**Kambala School Sports Precinct Redevelopment (SSD-10385)
Construction Environmental Management Plan, Condition C18**

I refer to the Construction Environmental Management Plan (CEMP) and Sub-plans submitted to the Planning Secretary in accordance with Condition C18 of SSD-10385 (as modified).

Attachment 1

Document Title:  
SEDIMENT & EROSION  
CONTROL PLAN - STAGE 1

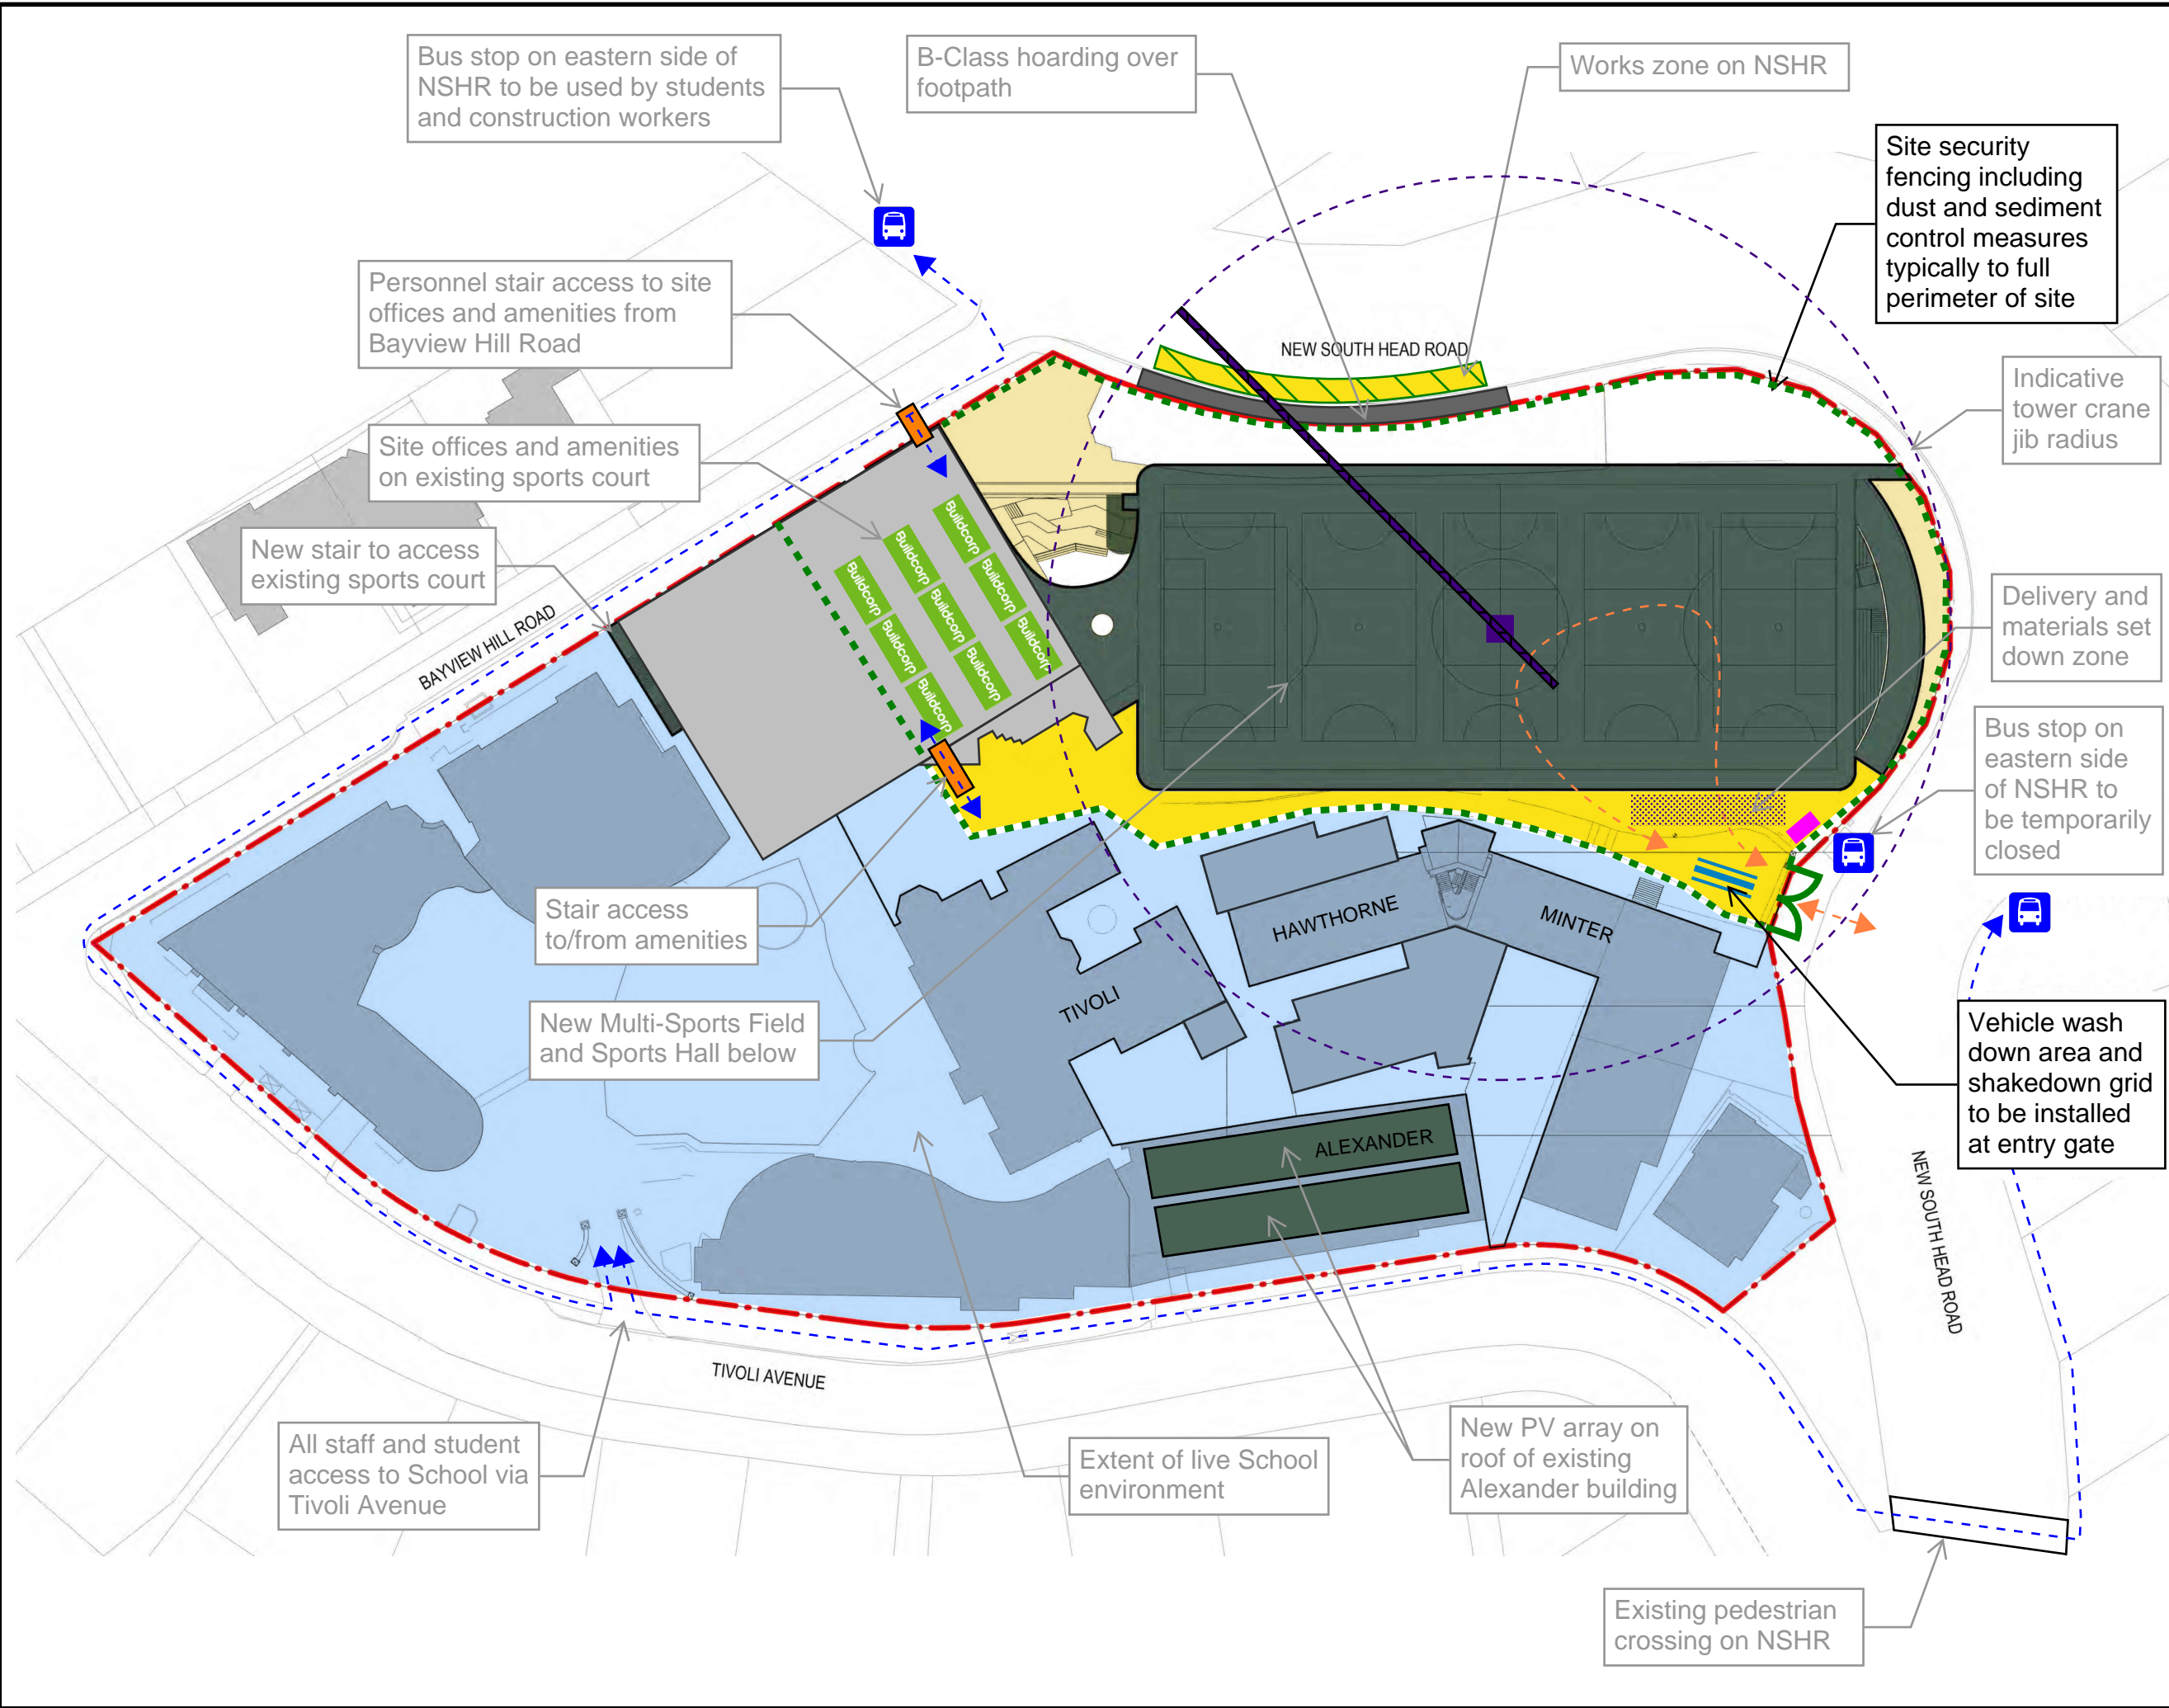
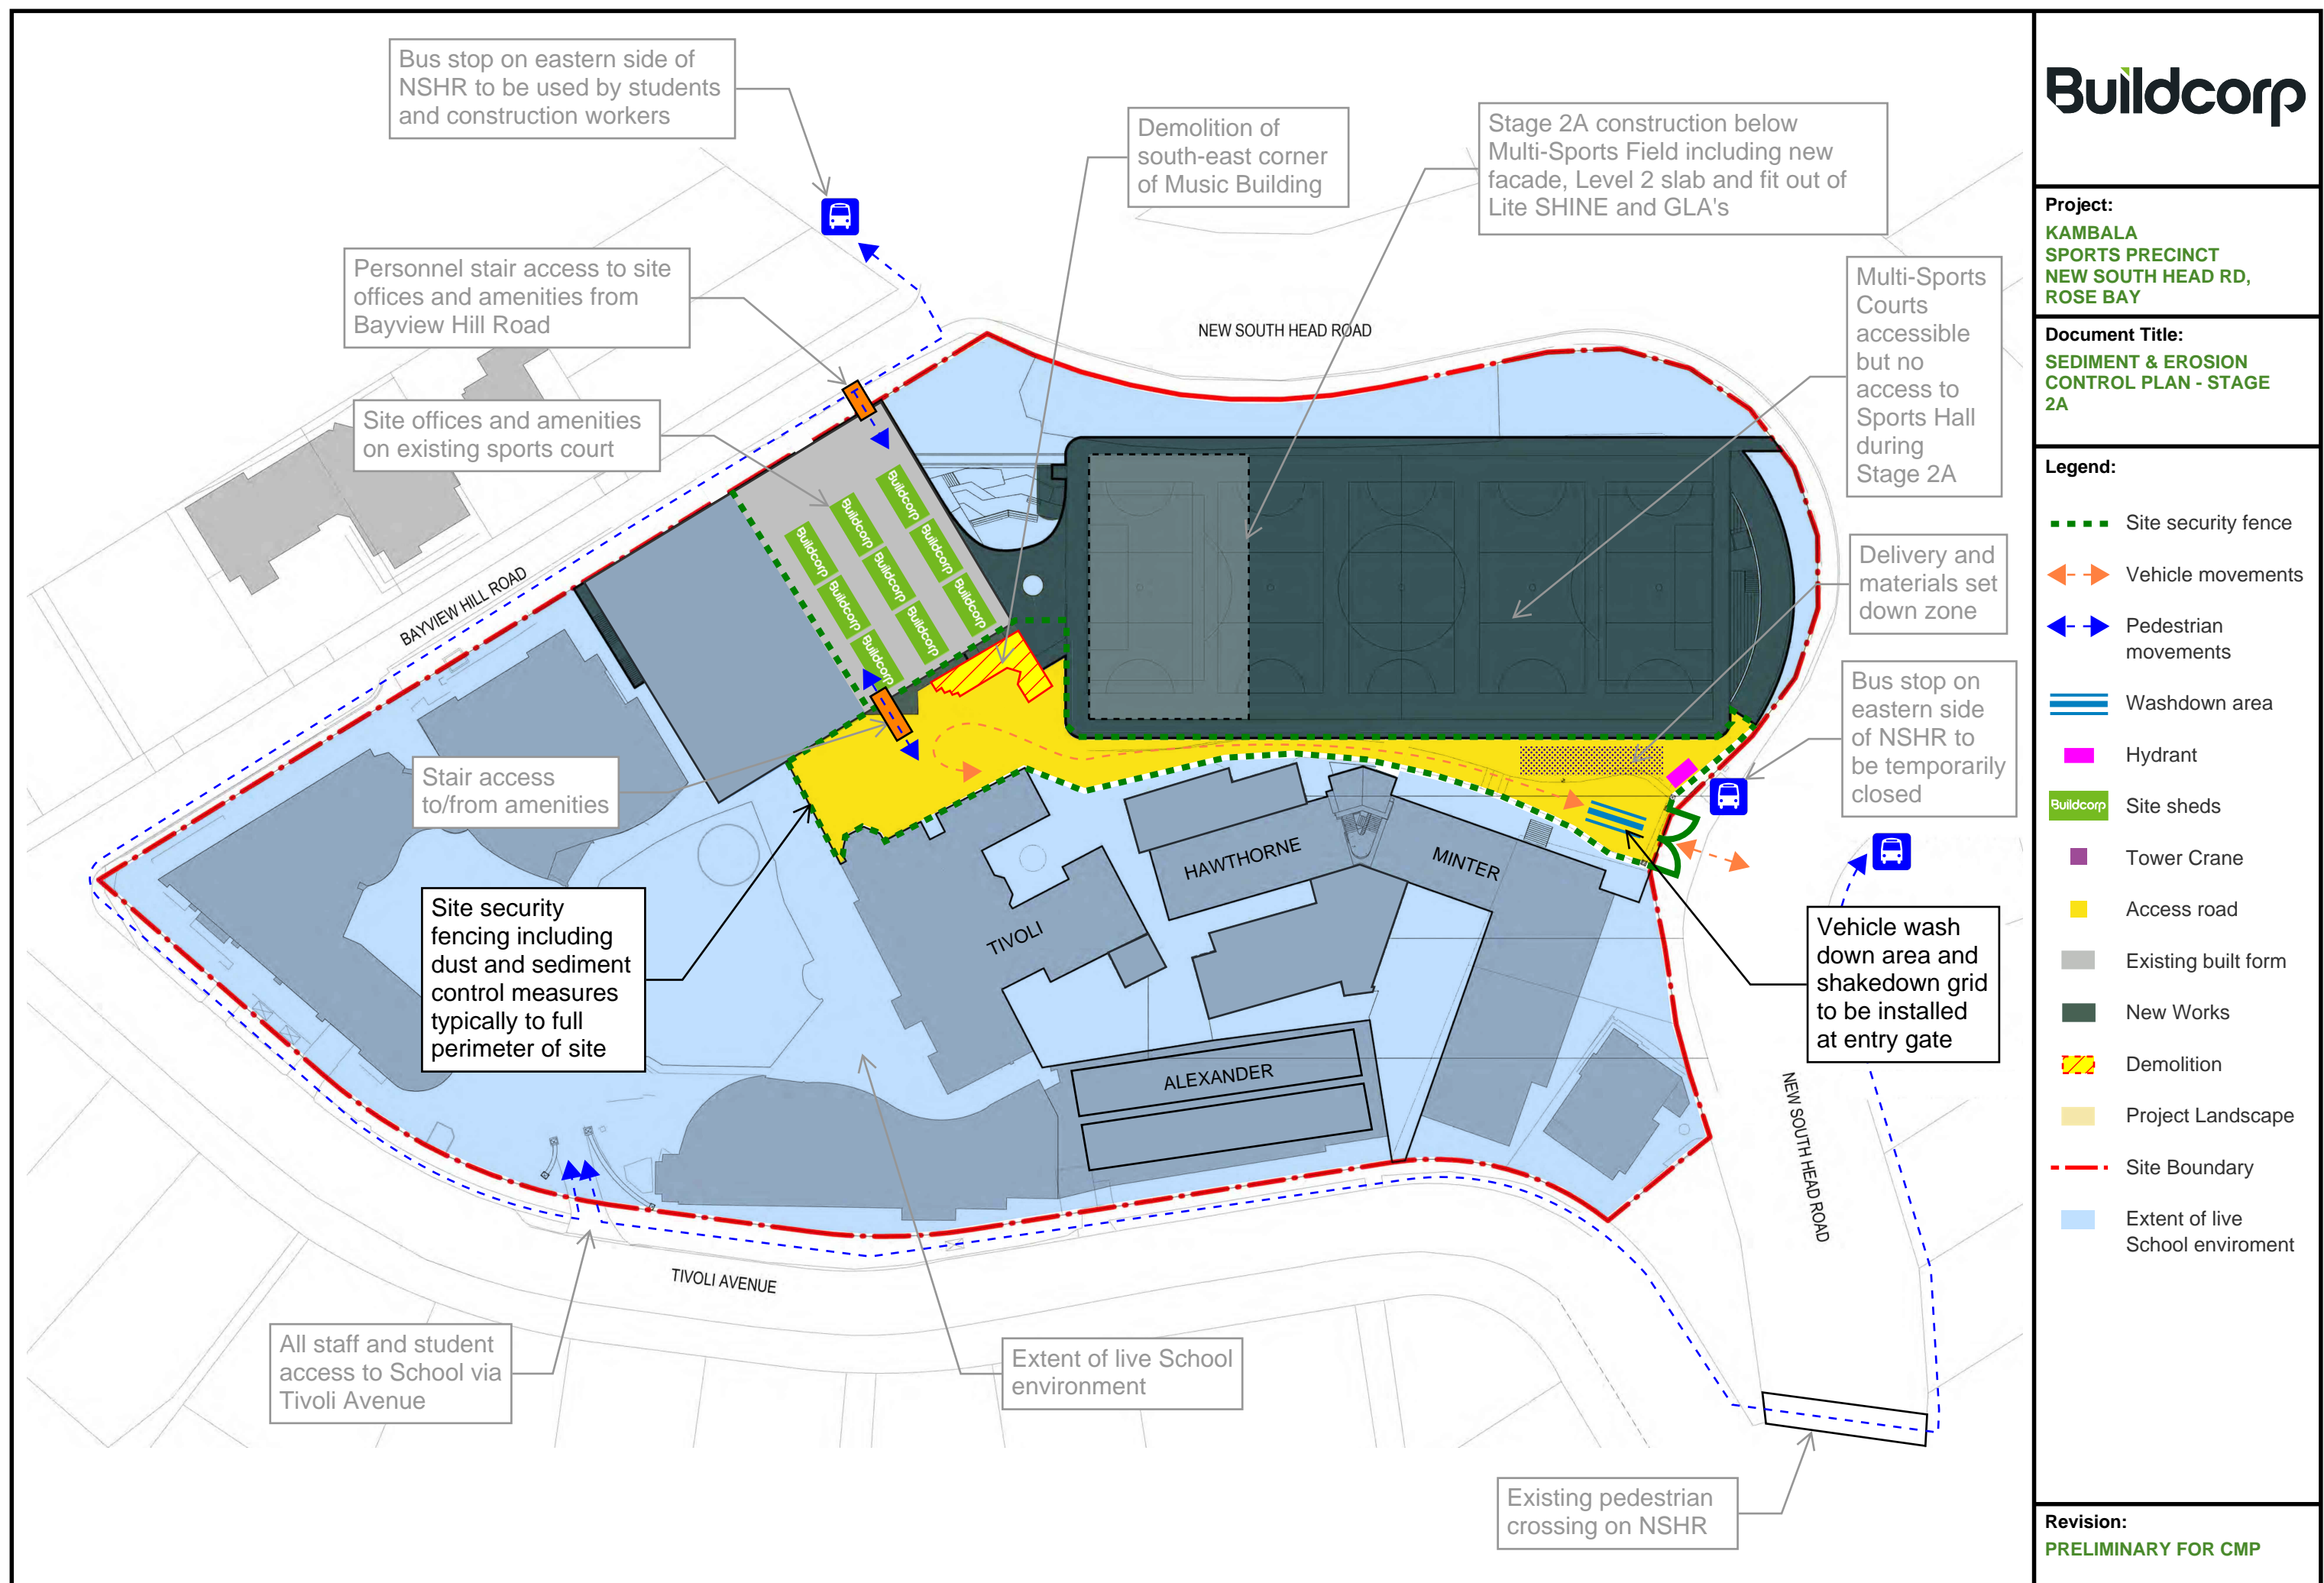
<u>Condition C22</u> The Applicant must prepare a Construction Soil and Water Management Plan (CSWMSP) and the plan must address, but not be limited to the following:	The submitted document to address Condition C22 is an Erosion and Sediment Control Plan (ESCP), Revision C, dated 15 August 2025, prepared by TTW Engineers. The drawings do not comply with the requirements of Condition C22. While the plans are useful, they

do not satisfy the several consultation and management requirements of the condition. As such, the drawings provide an incomplete plan of how the requirements of Condition C22 will be achieved. The Department considers that it is inadequate to rely solely on the ESCP to demonstrate compliance with Condition C22.

The Department recommends preparing a CSWMSP that is fit-for-purpose and explicitly addresses the requirements of Condition C22. In preparing the sub-plan, please consult with Woollahra Municipal Council as required by Condition C22(a).
